From: Kathryn Welch
Sent: 03 November 2020 16:09
To: Planning.Responses
Subject: FW: A/156/20/HH 16 Woodlands Close, Angmering
Attachments: 20064_411D.pdf; 20064_302A.pdf

I am writing to you in regards to the above application for which I am now the case officer. Having reviewed the plans and visited the location I am of the view that 1.5m close boarded fence to the front boundary is incongruent within the street scene, which is dominated predominately by low brick walls defining front boundaries to neighbouring properties.

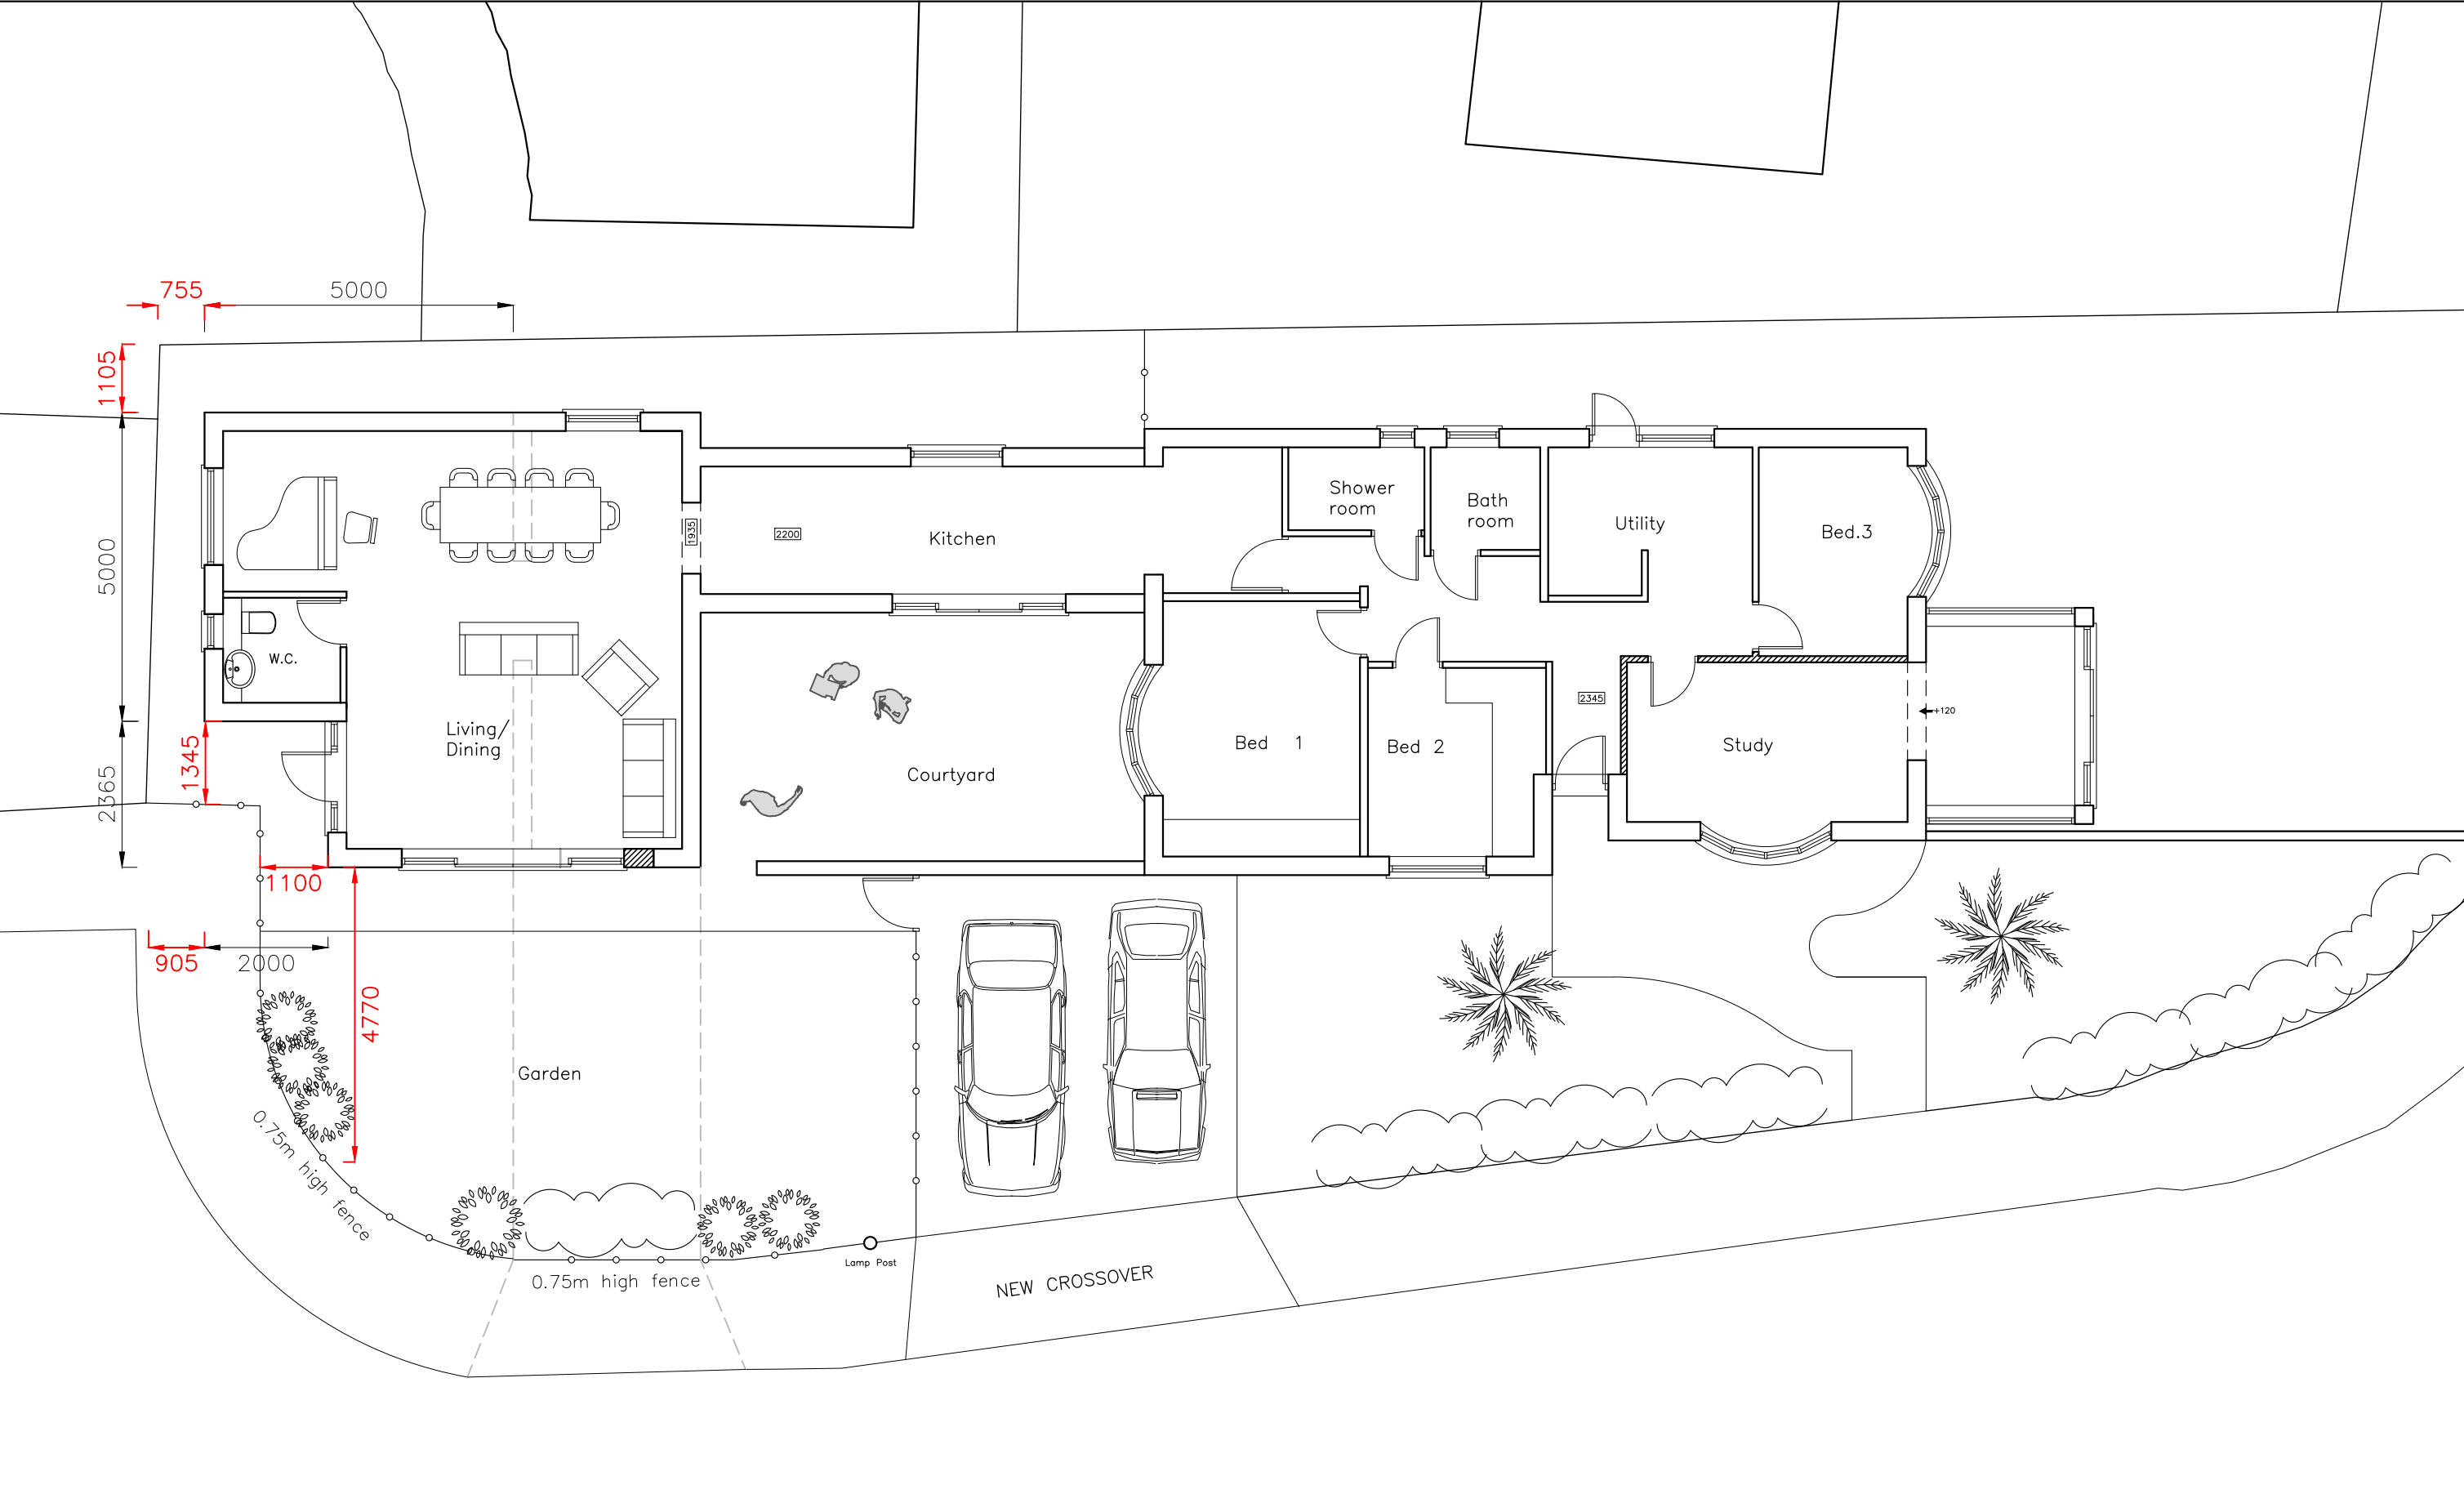
Currently, as the application stands I would be looking to refuse it solely on this point. Therefore should you wish to proceed with the application I would be grateful if you could consider the option of removing the fence from the submission? If this is agreeable to you, could I please obtain amended plans before the 6th of November, in order for me to re-consult the parish before the application deadline. Should you wish to pursue this option but not be able to provide the supplementary plans before this date, I would appreciate if you would agree to withdraw the application with a view to resubmitting the amended scheme in the future.

After consulting with our client, we have reduced the fence height so that the total height including the brick wall is no more than 1m. As our client would be allowed to do this anyway under Permitted Development we feel it is not unreasonable to show it on the drawings. Would you be happy to accept this? Copies of the amended drawings are attached.
